## **Deadline 4 Submission of National Highways Limited**

### **Written summaries of oral submissions made at ISH2 and ISH3 (including any response to action points)**

Application by Chrysador Production (UK) Limited for an Order granting  
Development Consent for the Viking CCS Pipeline Project

Planning Inspectorate Reference Number: EN 070008

Figure 5-1: Northern Compound Indicative Layout

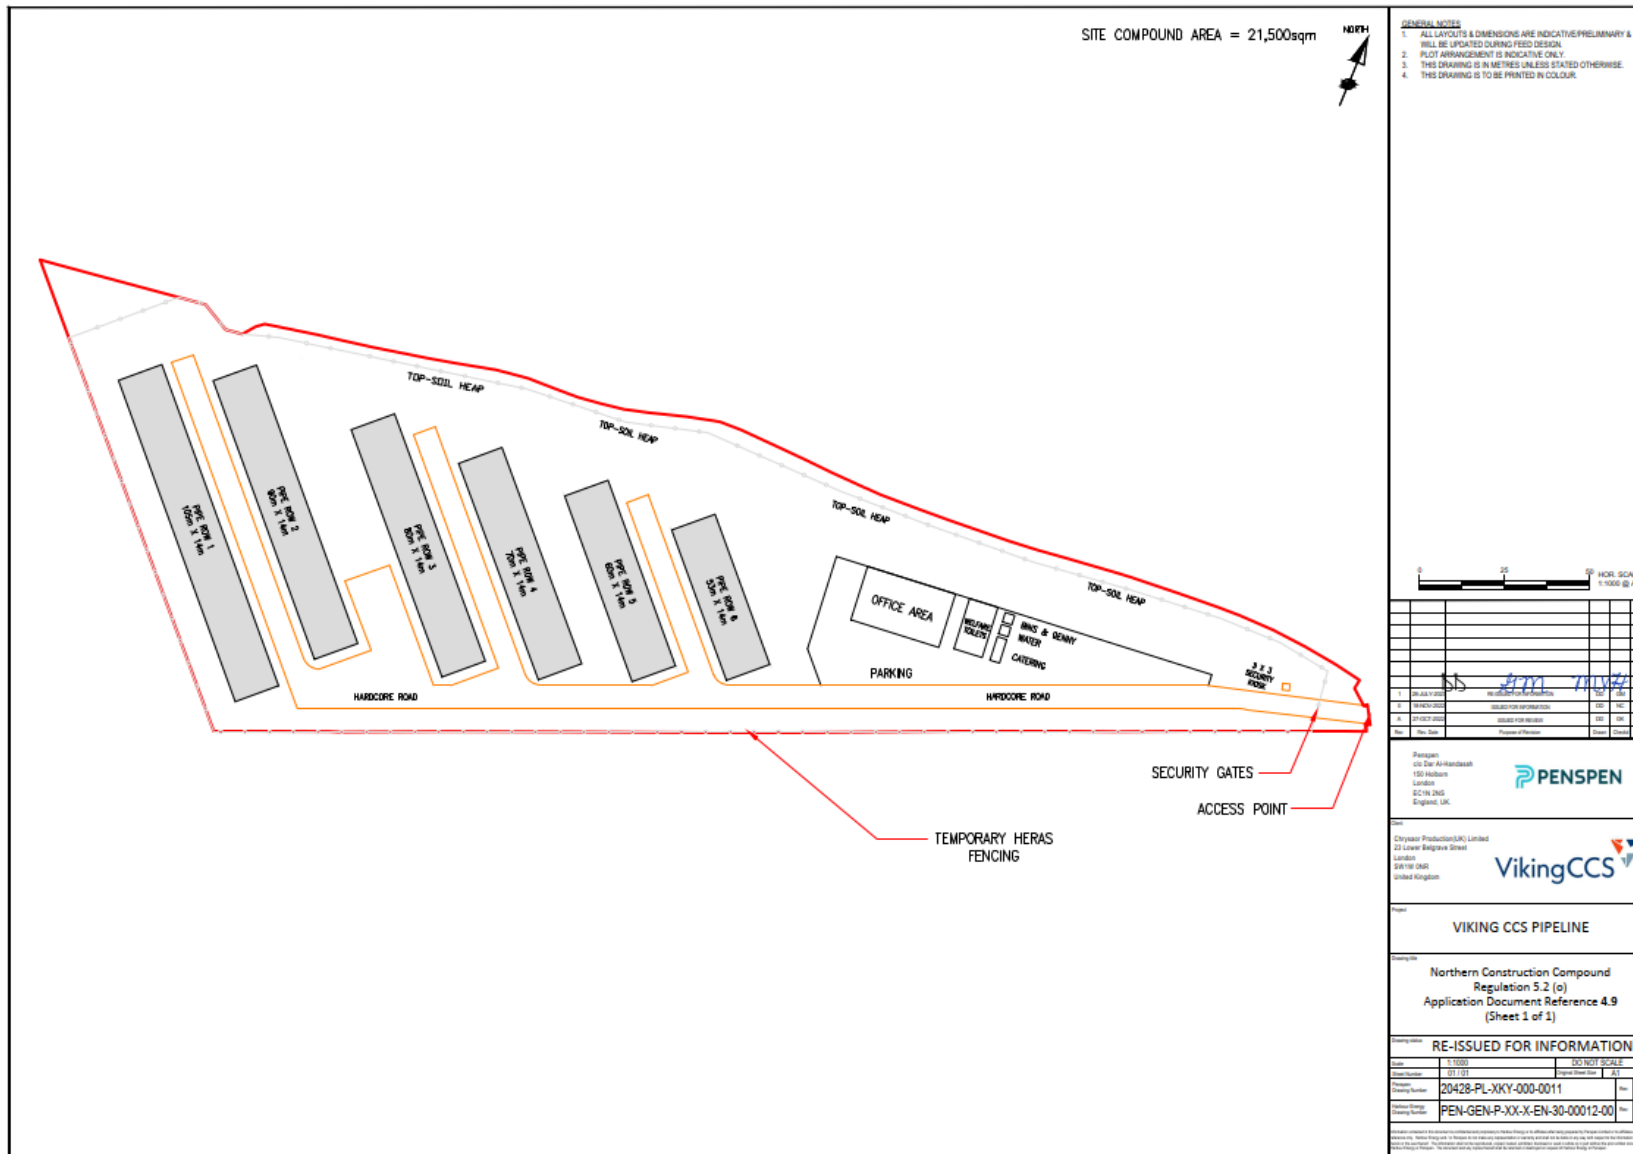
- 3.3 National Highways has requested to be considered as an approving body due to the volume of construction traffic (858 two-way trips per day) and its potential to result in a severe impact to the operation of the SRN, including the interrelationship between Habrough Roundabout, situated within the SRN, the site access to the proposed Northern Compound and Habrough Road.

- 3.4 It is important to note as a precis to this position, that no information has been provided to National Highways regarding the potential safety implications or impacts on the operation of Habrough Roundabout. Whilst National Highways has concerns that still need addressing in this regard, to avoid delaying the application process, National Highways has agreed to address these impacts at a later stage, in conjunction with the CTMP review. National Highways needs assurance that the proposed construction phase and cumulative impacts will not result in severe or unacceptable road safety issues and because it has agreed to push the assessment to a later date it is appropriate that it has more than just a consultee role at that time.

- 3.5 In principle, National Highways does not anticipate, at this stage, a severe road safety issue in relation to the use of the Northern Compound access, however, National Highways requires sufficient evidence is provided to ensure that the access is safe for the proposed use, with consideration of the concerns regarding the interrelationship between Habrough Roundabout, the site access and Habrough Road
